RE: Response Letter to Comments

Project Name: Take 5 Car Wash

We received the comments for the ICWG Snow Vista project; Please see below for our response to the received comments.

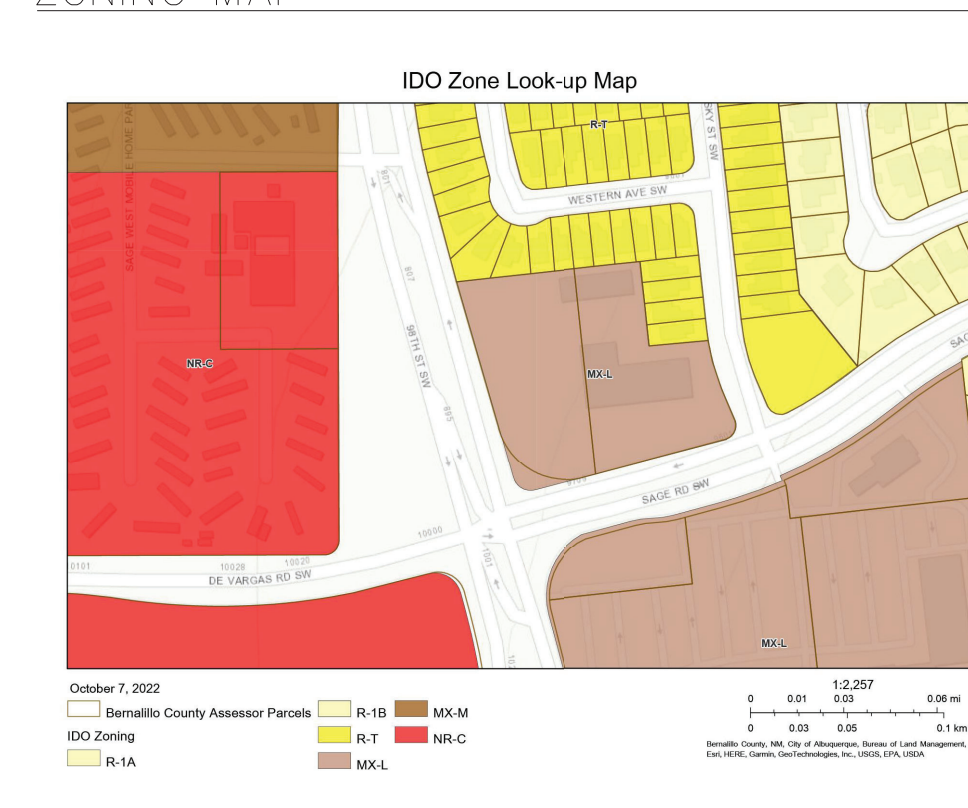
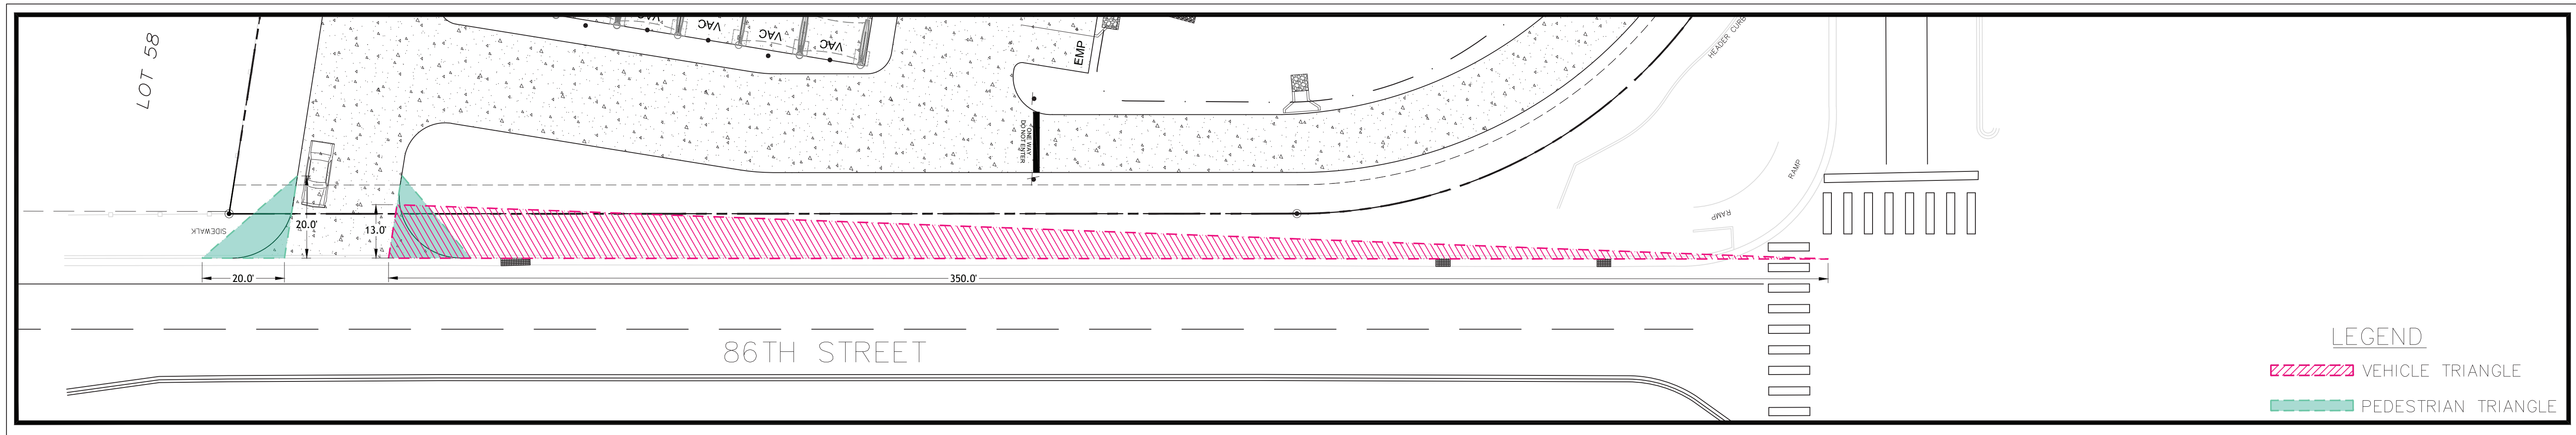
2. Define the property line.

4. Site plan showing 7' wide curb cut off 98th St. Please clarify, is this a curb cut or it is a storm drain inlet?

10. Please provide "One Way" signage and pavement markings at the entrance of the drivethrun lanes on the north east side of the building. Please show detail and location of posted signs and striping.

**Response: The property line has been called out on Sheet C-8.0.**

**Response: The dimension is referring to a storm drain inlet. The dimension callout has been removed from Sheet C-8.0.**

**Response: Signage and pavement markings have been provided on Sheet C-8.0. See details on Sheet C-8.2.**

FIGURE 7.4.115 Bicycle Parking Stall Layout Options:

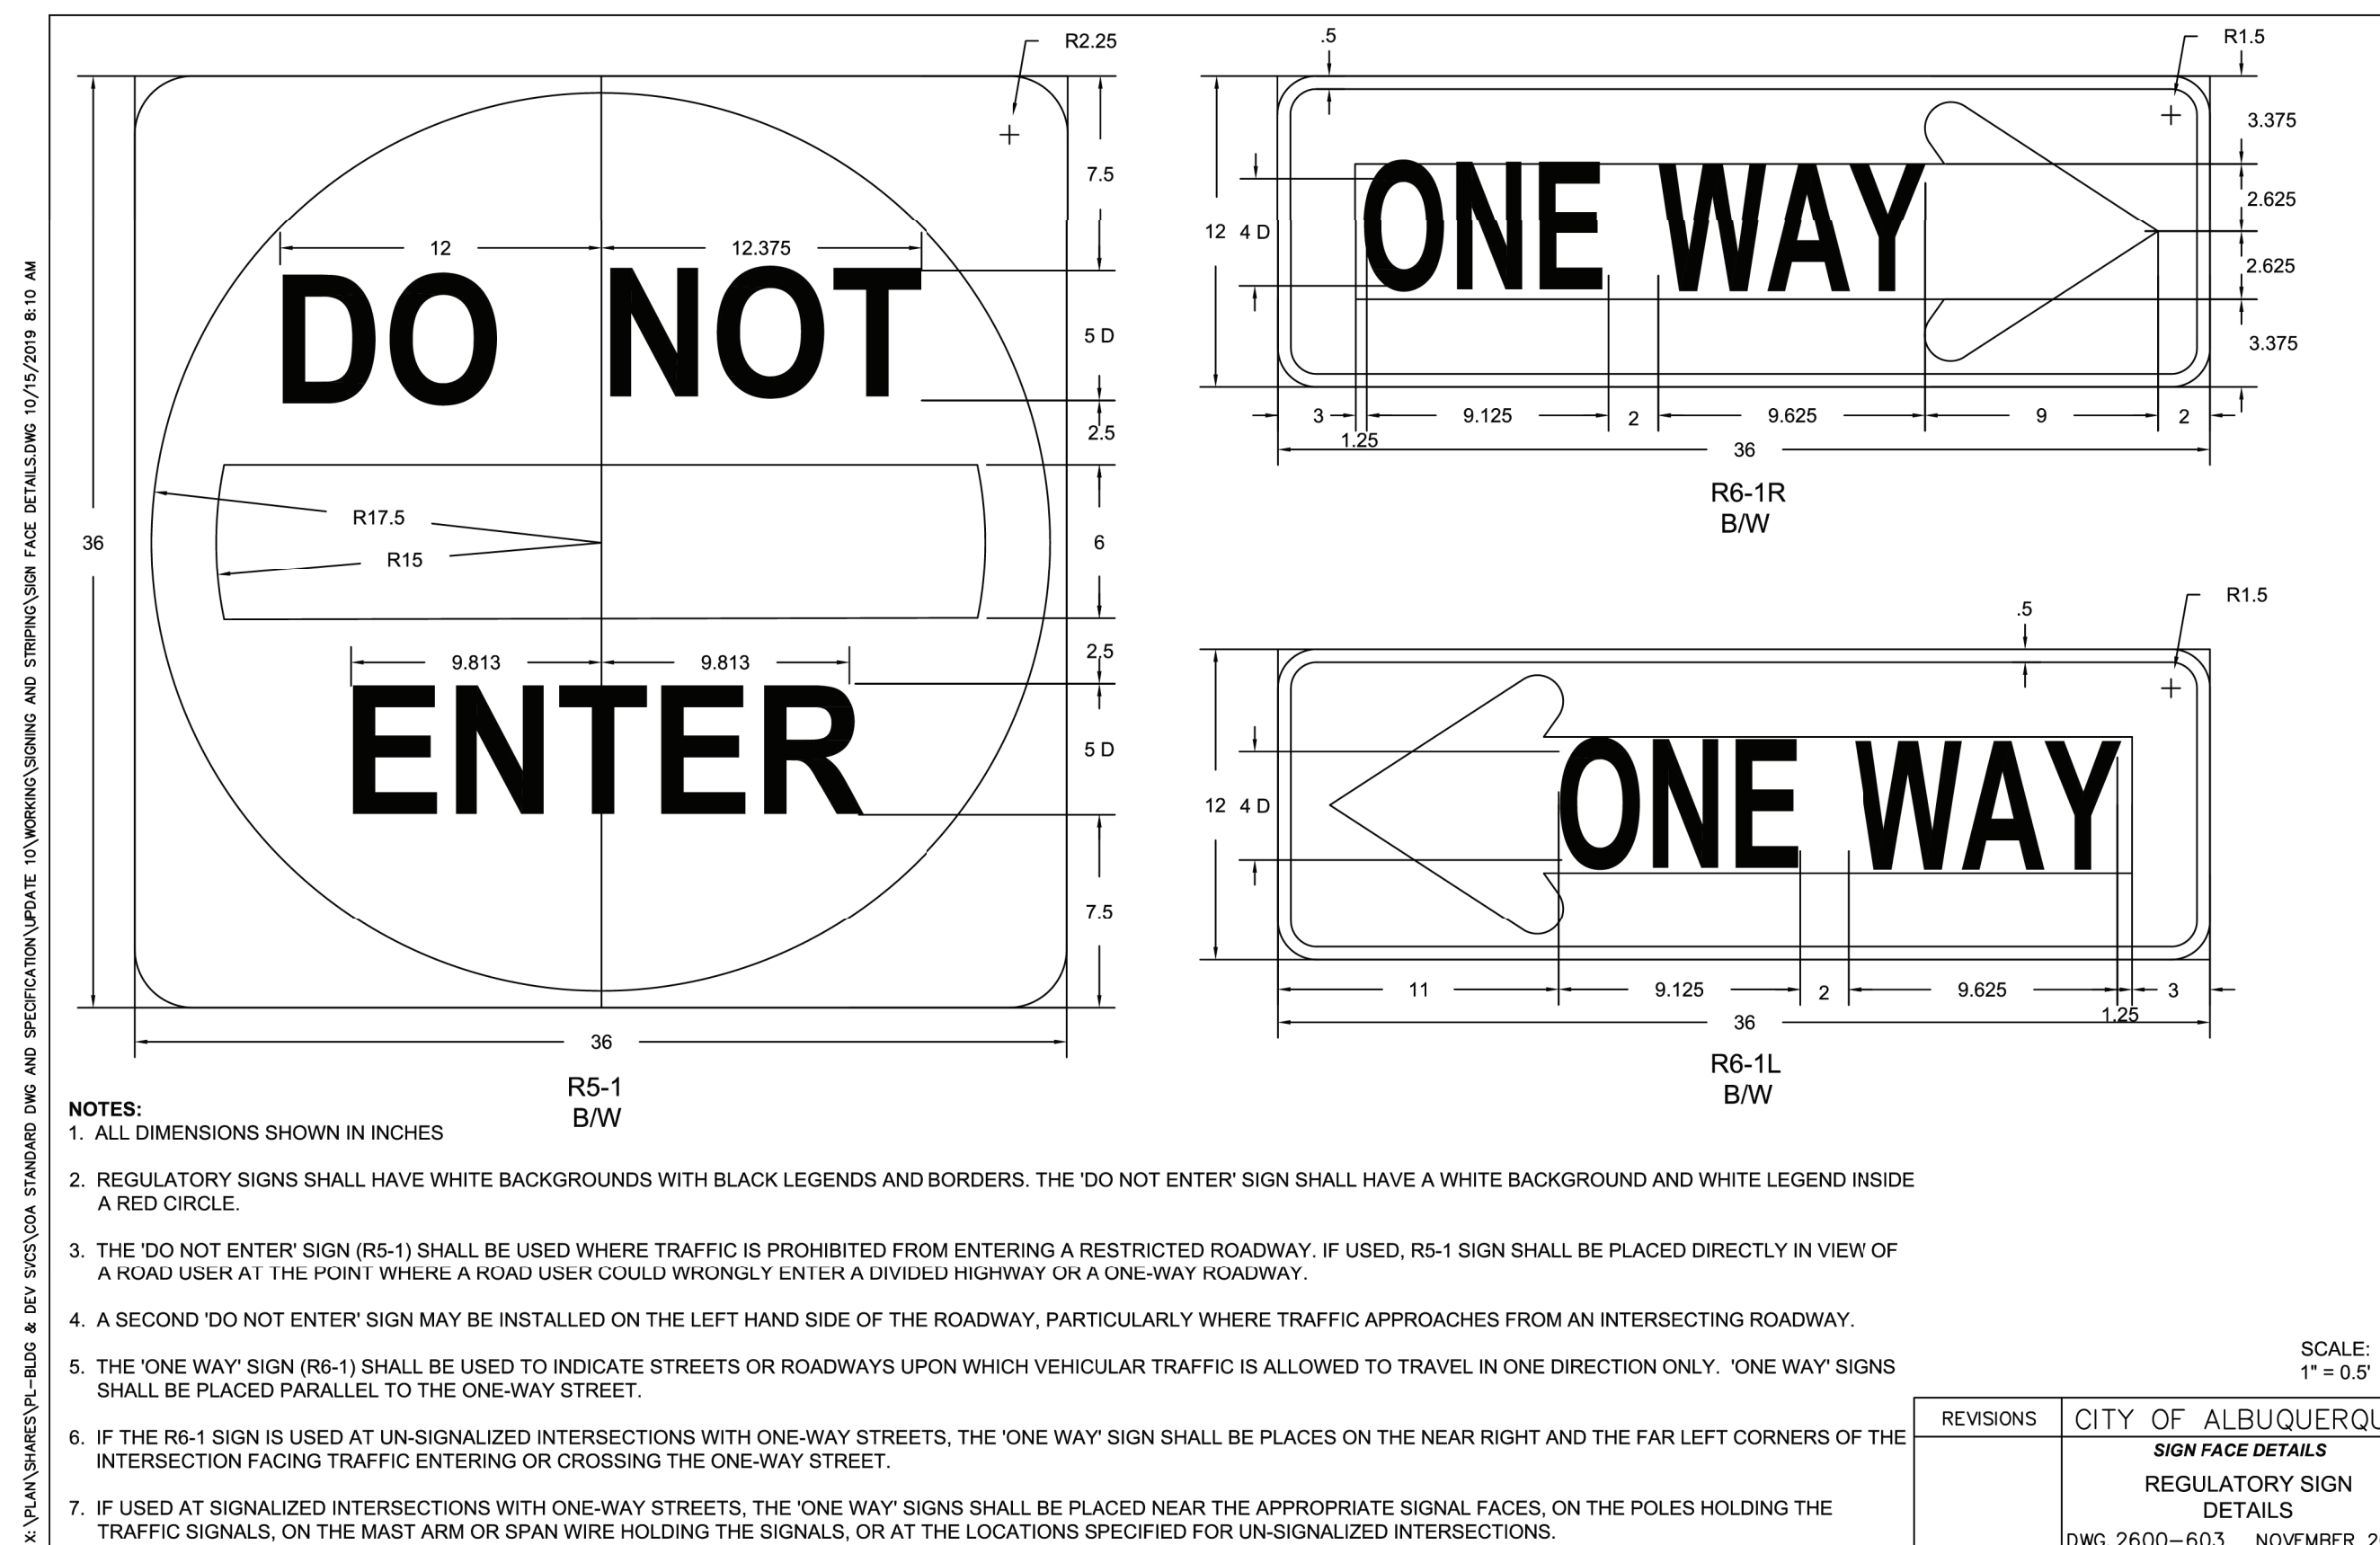
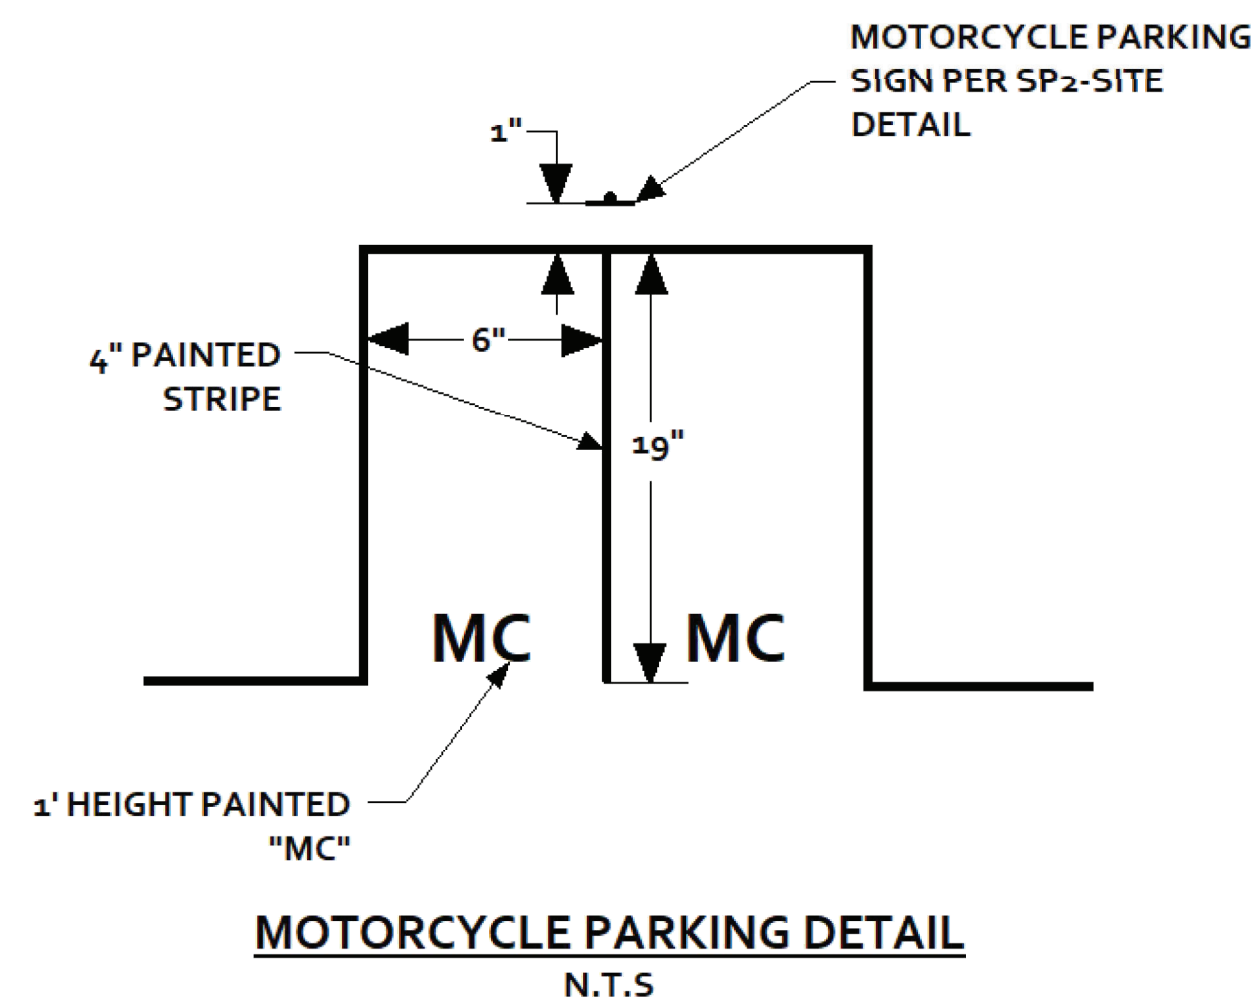
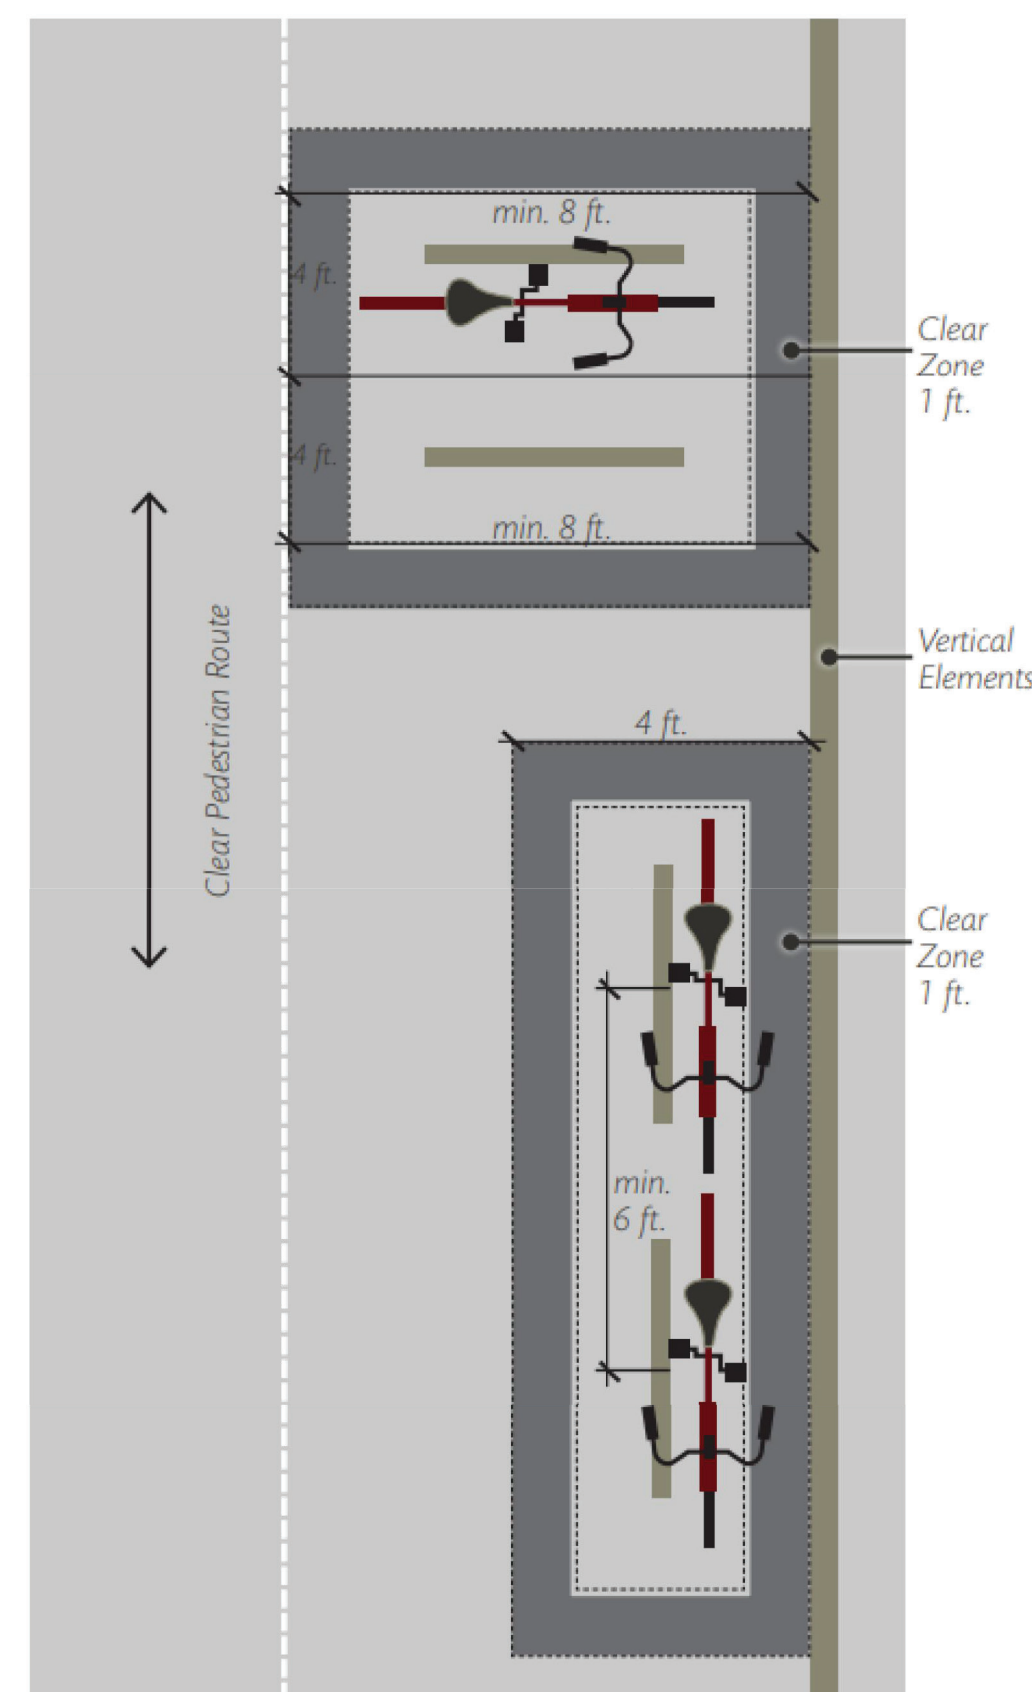
3. Detail sheet is missing. Please provide details for driveway access, proposed signs, and proposed interior ADA ramps.

5. The ADA accessible parking sign must have the required language per 66-7-352.4C NMSA 1978 "Violators Are Subject to a Fine and/or Towing." Please call out detail and location of signs.

6. Please show Motorcycle and Bicycle parking spaces on the site plan, and provide details.

**Response: The details can be found on Sheet C-8.1 and C-8.2.**

**Response: The detail has been revised on Sheet C-8.1 and the location of the signs has been called out on Sheet C-8.0.**

**Response: Motorcycle and Bicycle parking has been provided on Sheet C-8.0. Details have been provided on Sheet C-8.1.**
